Our Ref: WA/15/20/HH
Your Ref:

Town & Country Planning Act 1990 (as amended)
Town & Country Planning (Development Management Procedure) (England) Order 2015
Application for Planning Permission for Works or Extension to a Dwelling

Development Pitched roof to existing garage and new porch. Resubmission following approval of WA/20/19/HH
Location 11 Orchard Way Fontwell

1:1250
LOCATION PLAN

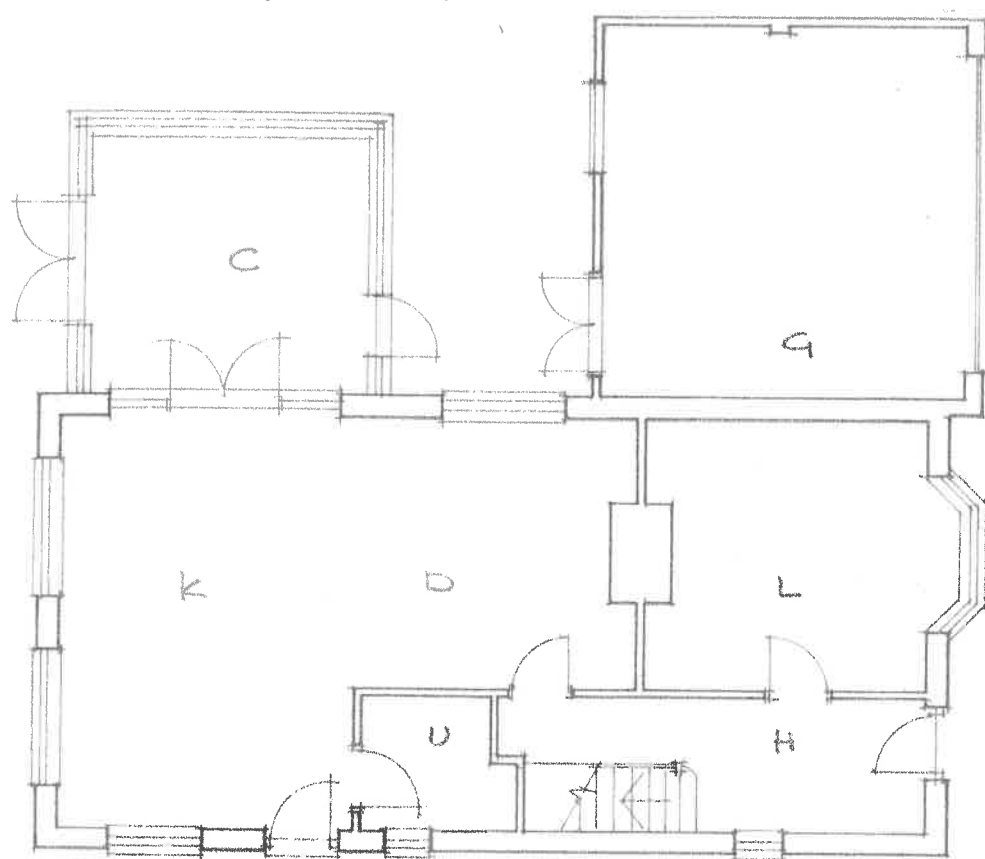
The submitted Location Plan has Elms Close, however our records have this as Deans Close. Please amend accordingly and re submit.
